From: [REDACTED]
Sent: 25 July 2023 10:37
To: Planning Comments (Shared Mailbox)
Cc: Lizzie Mugova; Kirsty Shirley; Cllr Stubb [REDACTED]
Subject: Planning Comments
Categories: App in use

Application Number 6/2023/1442/PN27
41 Northaw Road East

Barry Knichel
Chair, NCPC

Proposal existing and proposed layouts

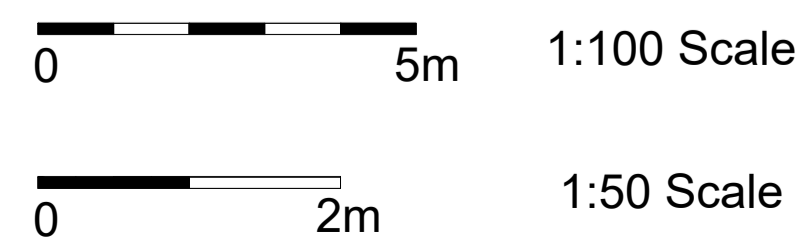
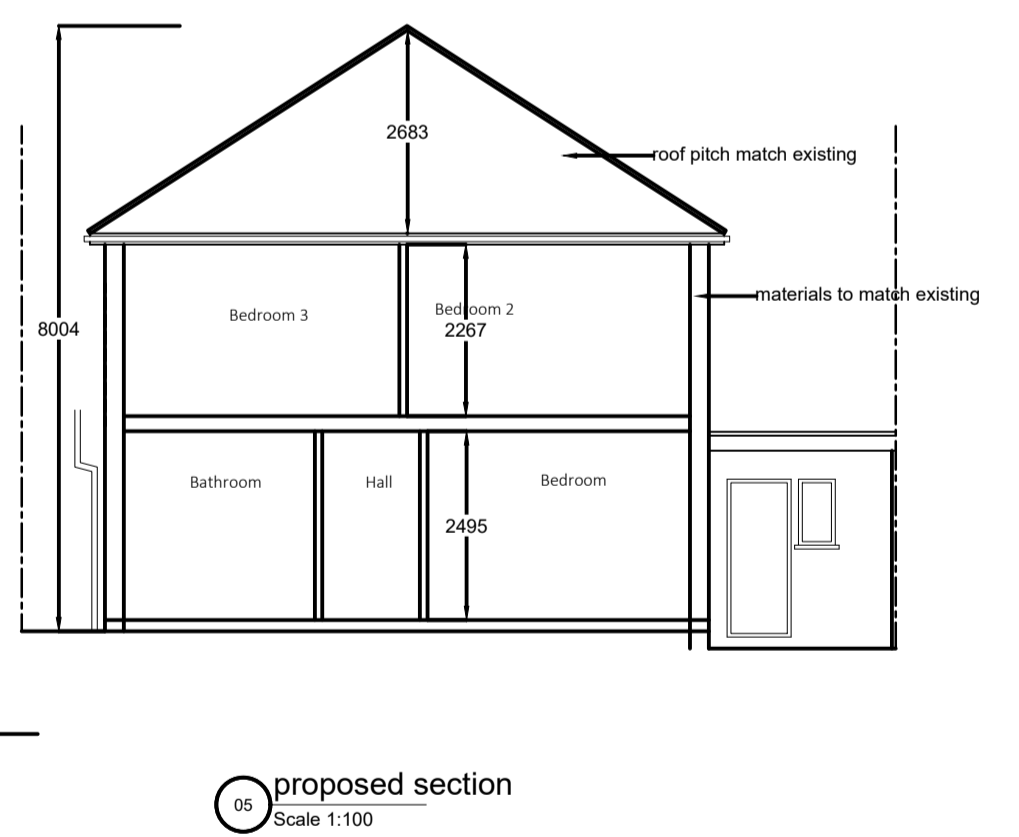
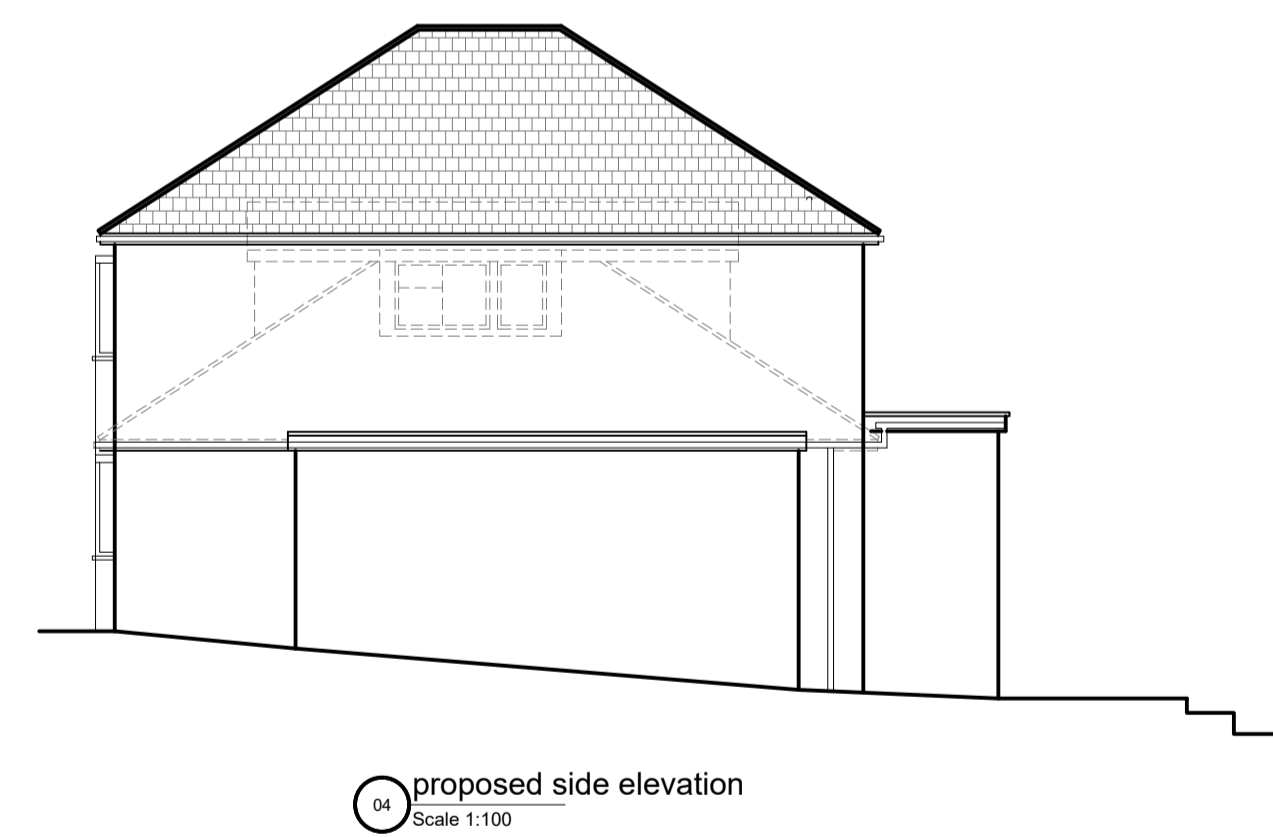
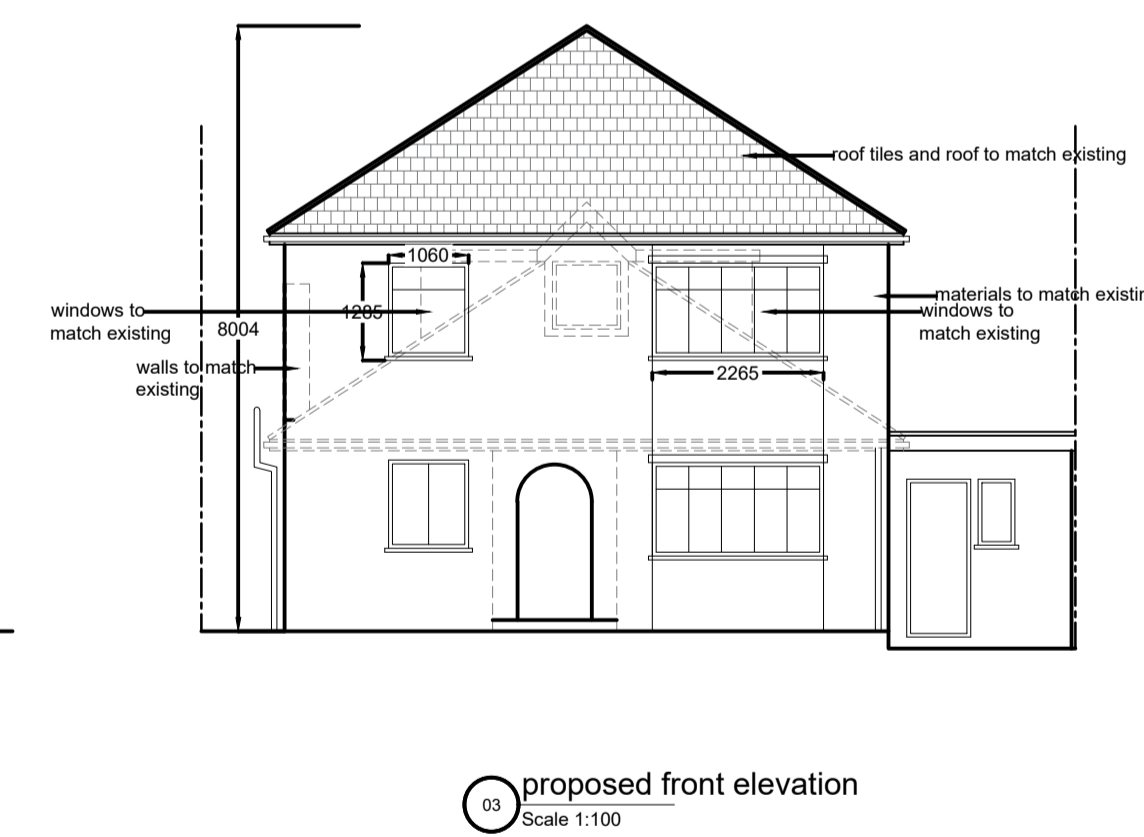
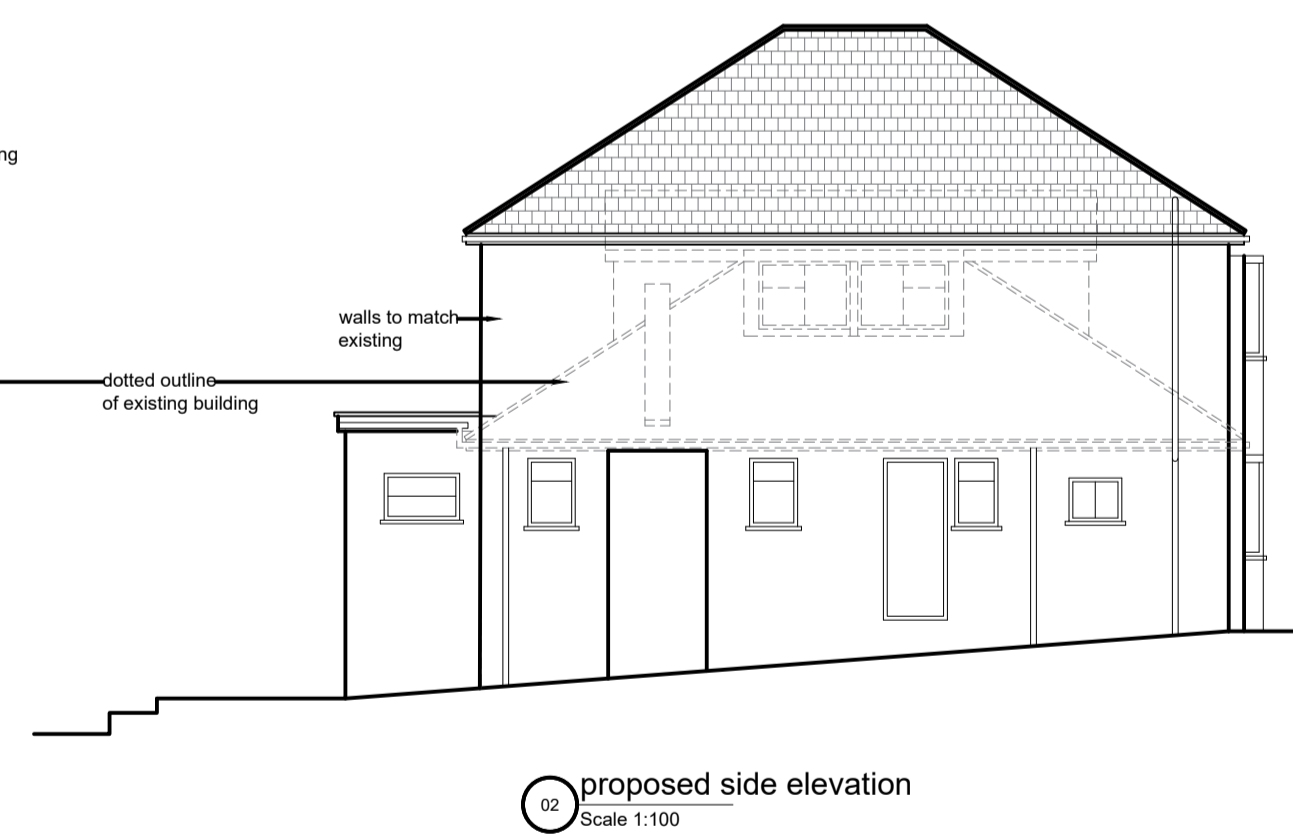
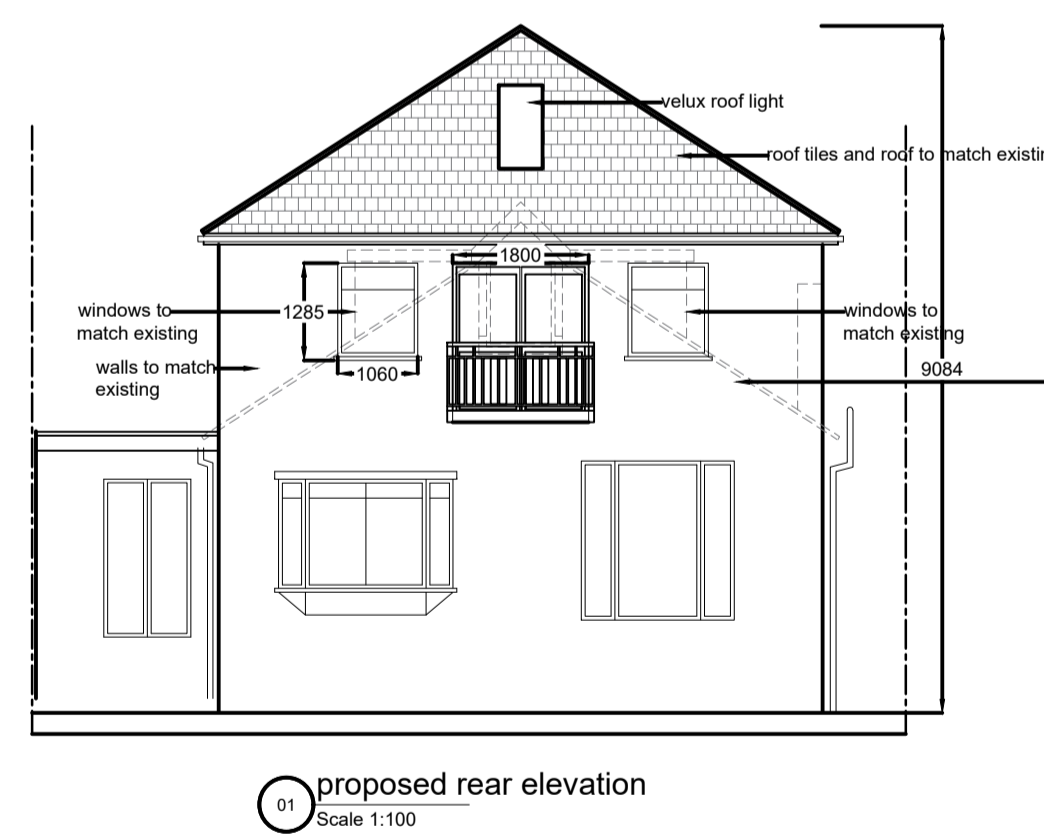
Comments: We wish to raise a Major Objection on the grounds of: this is an application to create a 2 storey house in a row of chalet bungalows. It contravenes NP Policy D1 (e) in relation to ridge heights. It is out of character with neighbouring buildings as well as the character of the whole area.
